Application No: EP/91/21/HH
Site Address: 23 Seaview Road East Preston BN16 1LX
Description of works: Replacement of existing roof including loft conversion and raising of ridge and eaves by 500mm. Dormer to rear roof slope. Alterations to existing external materials. Insertion of new bi-folding doors to rear of property. Construction of new porch.

Thank you for your internet representation made on 19th August 2021 which has been recorded as an objection with the comments as follows:

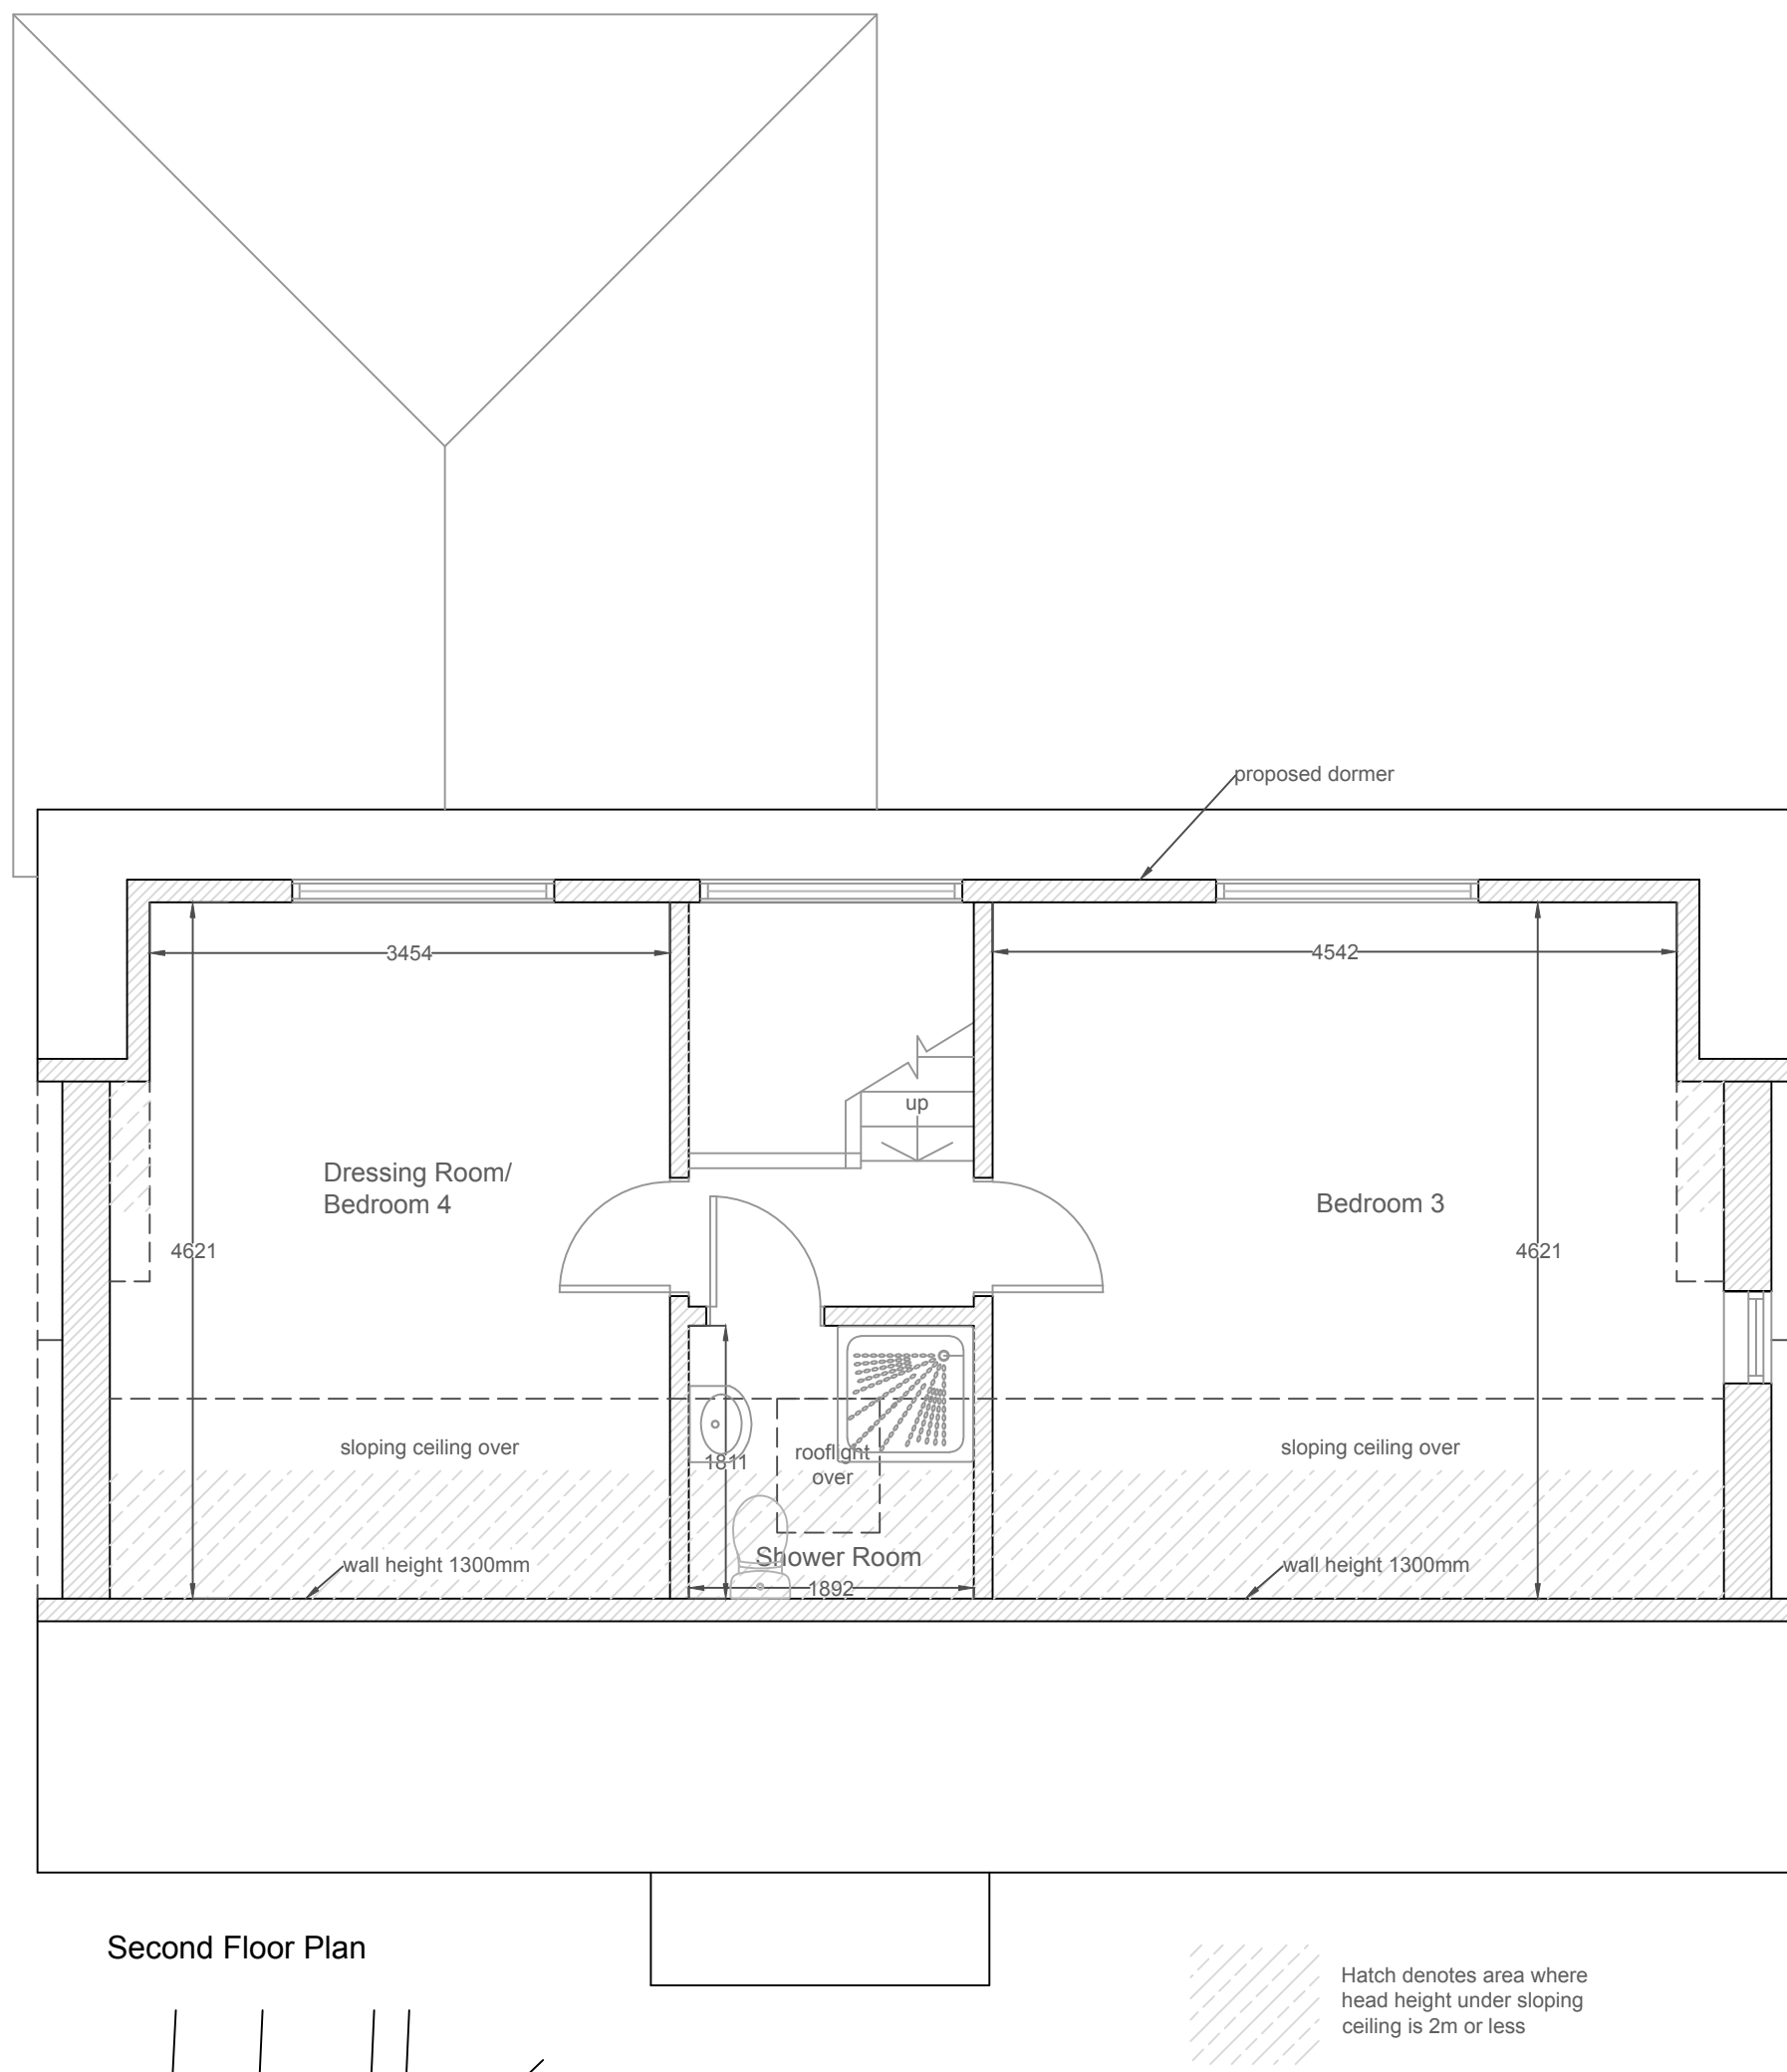
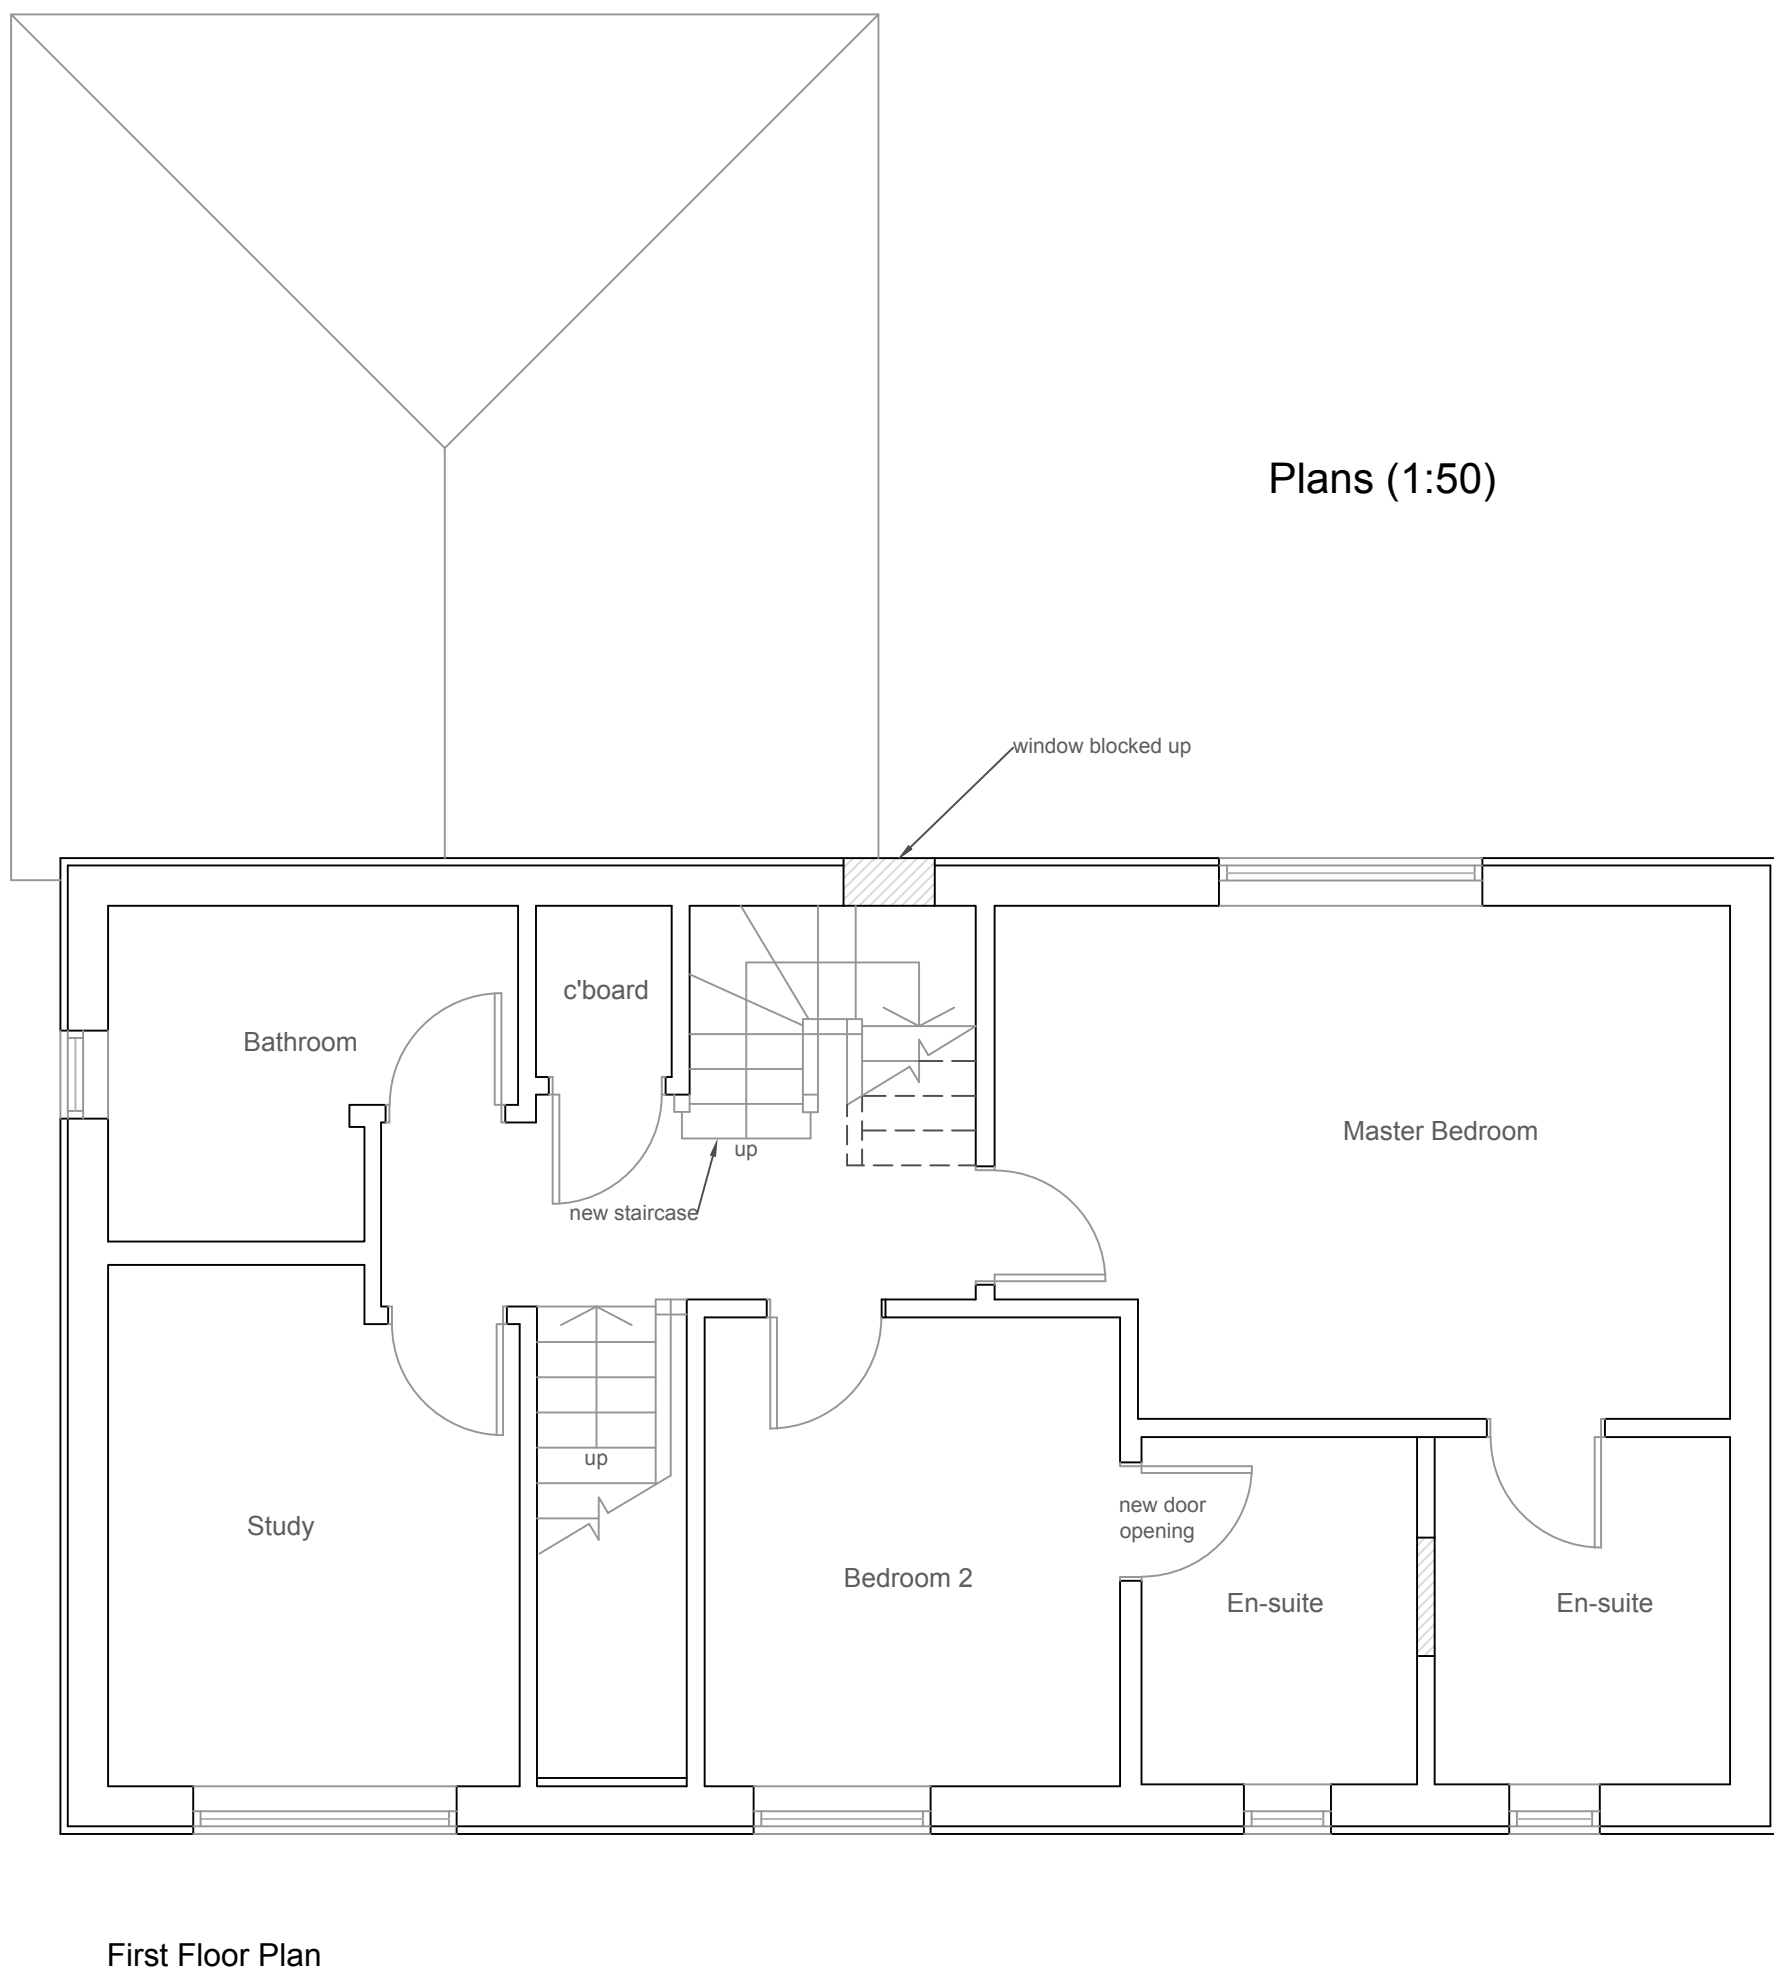
The proposal is to extend a property on a site which we believe is already cramped. Although the footprint of the building does not appear to be increasing, the proposed additional height of the property could result in the site looking overdeveloped.

Whilst the front of the property remains relatively unchanged, the rear elevation will be changed dramatically, resulting in visually a three-storey property, clearly visible from the busy footpath to the west of the site. This council believes the proposal to be contrary to Policy 1: Housing General Principles of the made East Preston Neighbourhood Plan, paragraph 4.14 of which states, New or altered buildings that exceed two storeys in height will rarely be acceptable. Rooms in the roof space may be permitted if the dormer windows are small enough to be subservient to the appearance of the roof as a whole. The proposed almost full-width dormer is unlikely to be considered subservient by many and will leave very little of the pitched roof visible. It is also possible the windows in the proposed dormer will increase overlooking of neighbouring properties and reduce the privacy currently enjoyed by the occupants of those premises.

The provision of a fourth bedroom could result in an increased demand for parking at and around the property. Currently, there appears to be limited on-site parking because of the layout of the area in front of the property. There is no indication this will change so will the revised property be able to provide the required amount of on-site parking. Seaview Road is a very popular road for parking, especially during the summer.

The committee was also concerned about the choice of materials. We do not believe there are any cedar timber-clad buildings within sight of the front of this property.
